Application no: **3/2021/0803**

Address: **Fell View Barn Barret Hill Brow Bolton by Bowland BB7 4PQ**

Proposal: **Proposed change of use of agricultural building to education barn.**

The Local Highway Authority have viewed the plans and highway related documents and have the following comments to make:

PROPOSED SITE PLAN

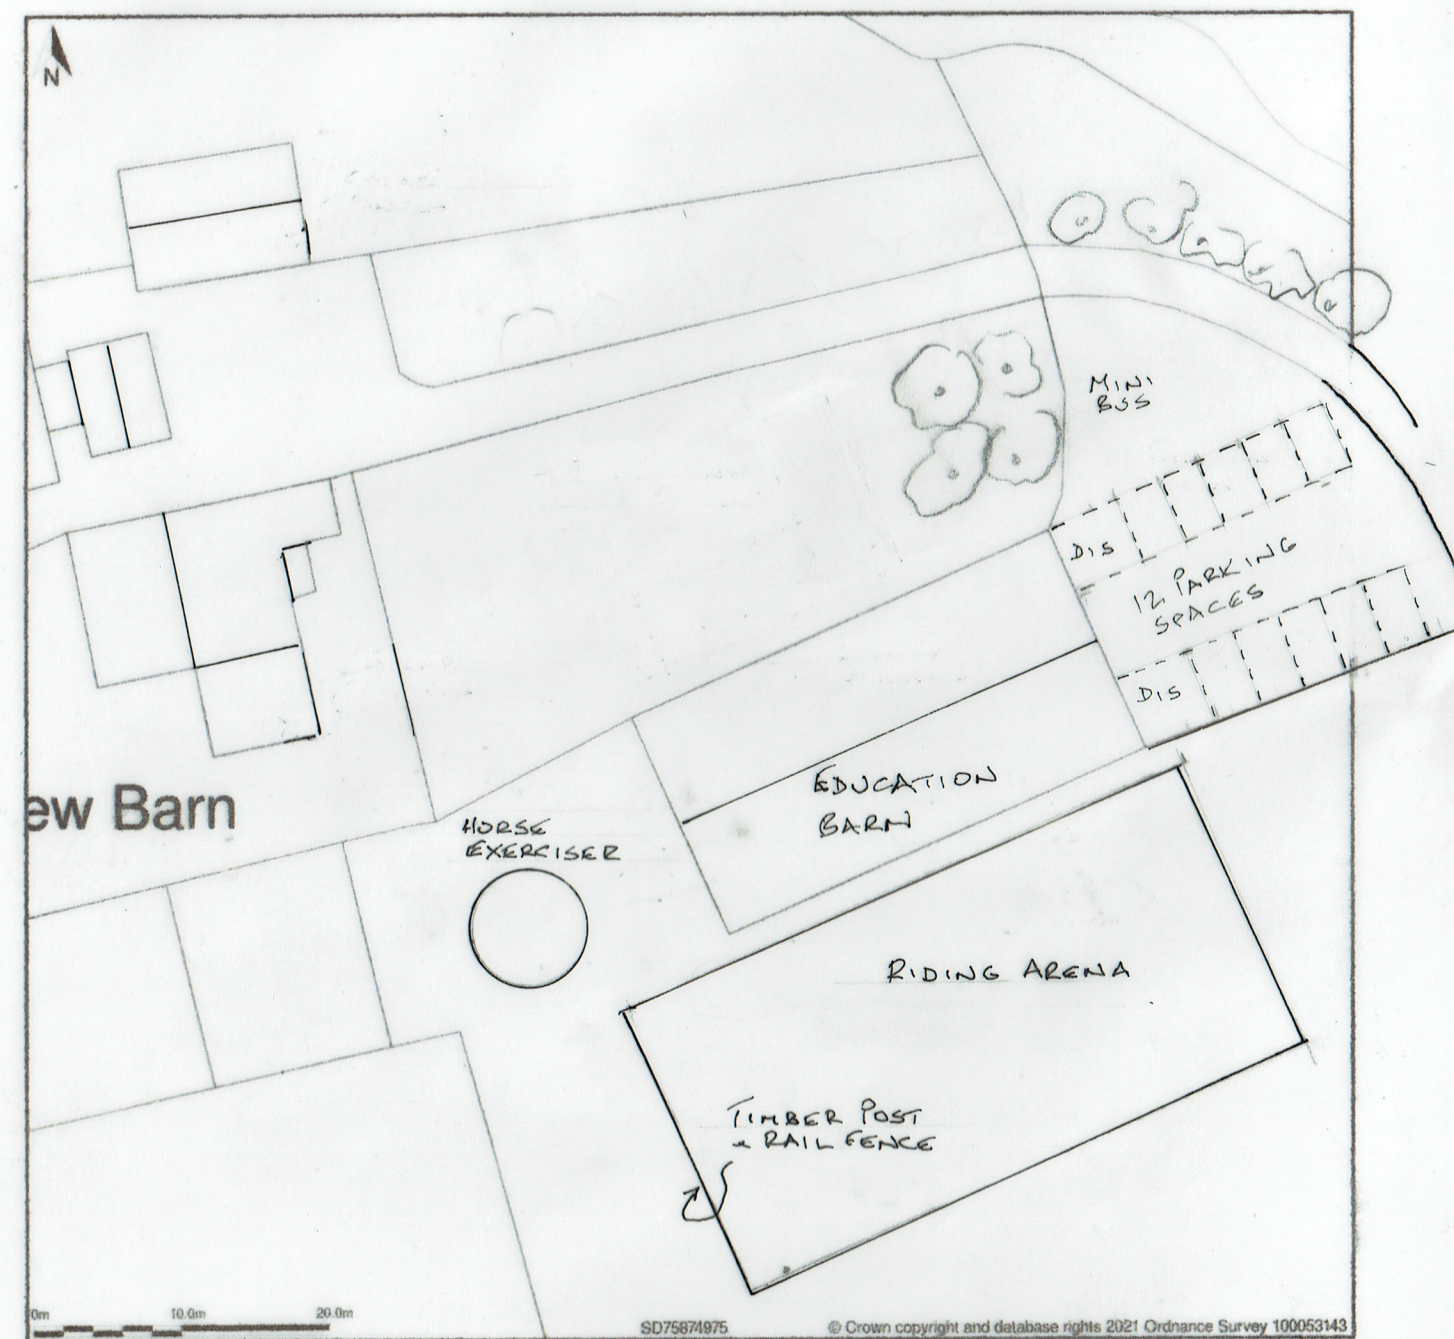
The LHA have reviewed the Application Form and the drawing titled "Proposed Site Plan" and understands that the site will provide 12 car parking spaces. While the LHA would normally require an education barn with the internal floor area measuring 450 square meters to provide 13 car parking spaces, due to the education barn being classed as a "training facility" in the Joint Lancashire Structure Plan, the LHA will accept the shortfall.

However, these car parking spaces should be drawn and shown fully on a parking plan of the site.
